File: SF18/73342  
Job ID: DOC18/640865  
Our Ref: SSD 8922

**RE: Major Alterations and Additions to the Stevenson Library Building, Scots College  
29-53 Victoria Road, Bellevue Hill (SSD-8922) – Notice of Exhibition**

1 Proposed Roof Plan RL 75.25
 Scale: 1:200

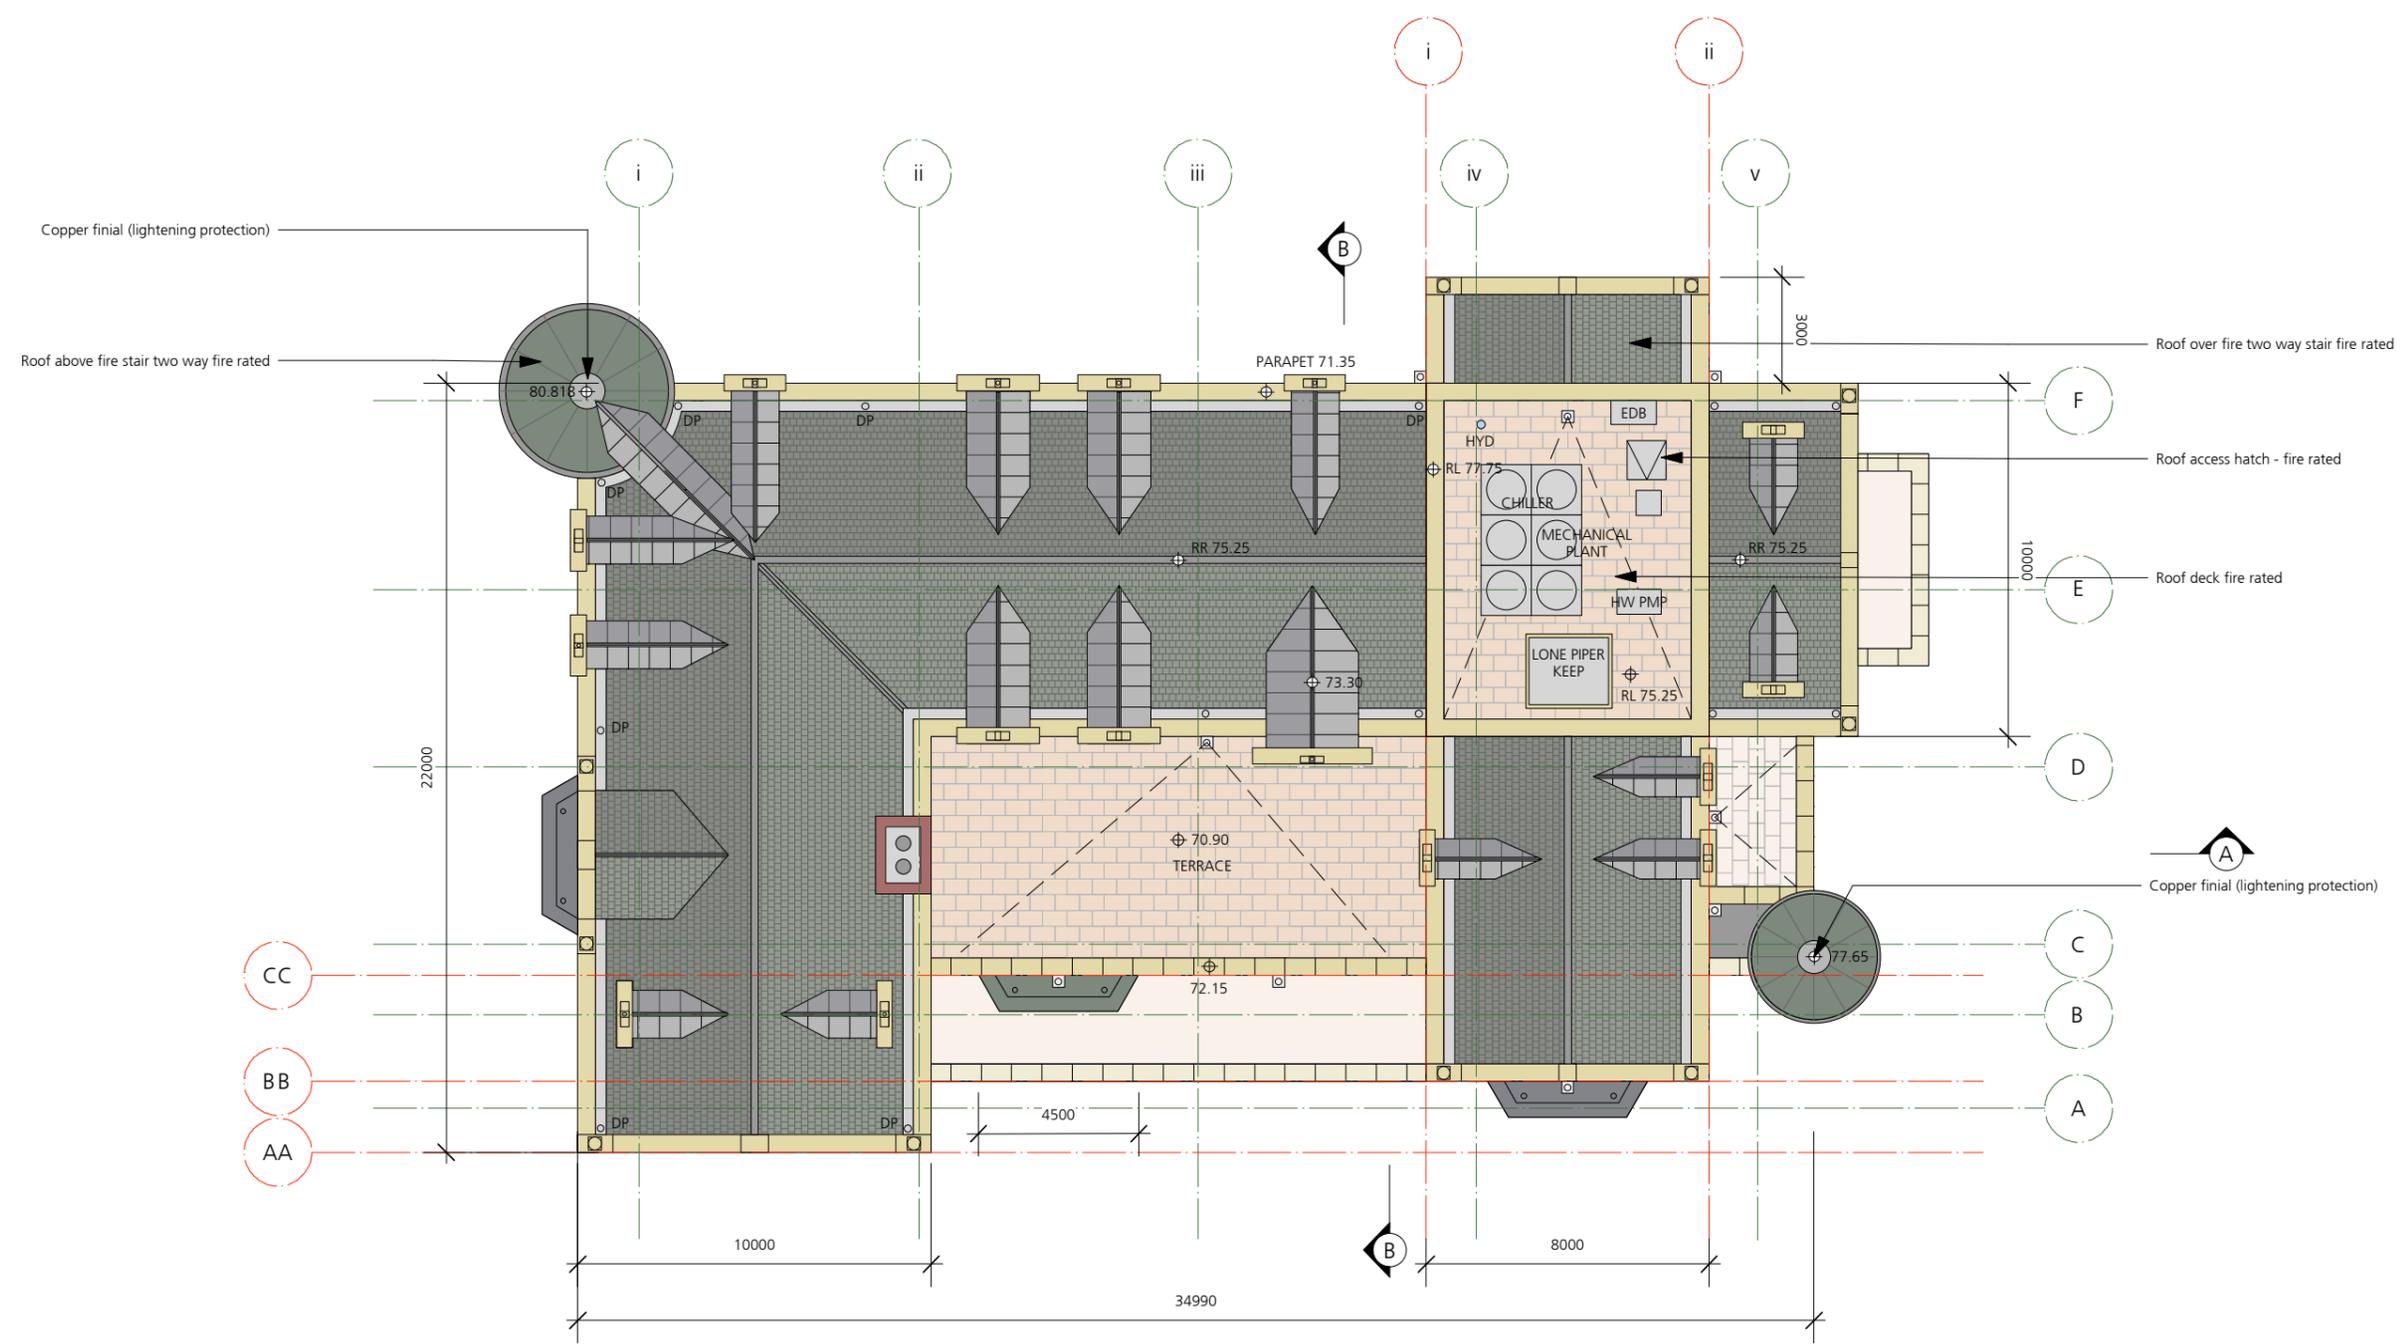
However, the proposed Scottish Baronial style library is higher than the existing library because of the steep roof form. It is located beside Aspinall House (formerly St Killians) listed as a heritage item on the Woollahra LEP which has complex massing but a relatively simple form of roof form. The proposed library roof presentation is complex with high turrets on the two corners, multiple oversized dormer windows on all facades and a large roof terrace surrounded by heavy ornate balustrading. The roof balustrading mimics the balustrading on the tower of Aspinall House but is much larger in area and length when seen from a number of viewpoints. The complicated and more massive roof form with its high turret and dormer protrusions, and prominent balustrading to the roof terrace would overshadow and diminish Aspinall House.

- ***The roof design shall be simplified to avoid visual competition with the Aspinall House.***
- ***A photographic archival recording of the Stevenson Library should be prepared prior to the commencement of works, in accordance with the NSW Heritage Division publications "How to prepare archival records of heritage items and Photographic Recording of Heritage Items using Film or Digital Capture". A copy of these archival recordings shall be provided to Woollahra Council;***
- ***The history and development of the site should be interpreted on the site by introduced devices such as plaques that detail the history of the site and its historical associations as outlined in the SOHI;***
